## Application for a Non-Material Amendment Following a Grant of Planning Permission

CA/20/01097 - Erection of perimeter fencing and an extension to the existing hardstanding - FULL PERMISSION GRANTED

CA/20/01097

Fence Elevation as Proposed

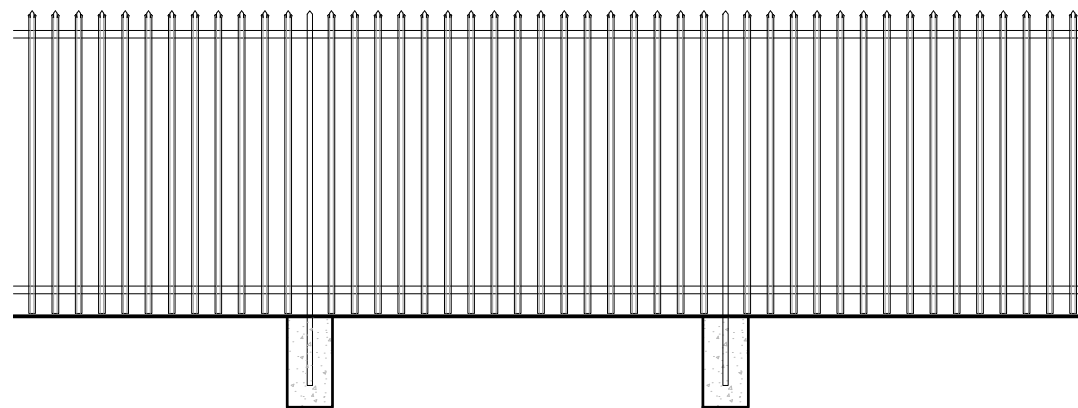
Changes we would like to make are to amend fence from a galvanised finish to a green powder coat finish. This would be more aesthetically pleasing for neighbours, as it would blend into the trees better.

We would like to change the fence from Galvanised finish to Green Powder coat finish as this will be more ascetically pleasing on the eye for neighbours.
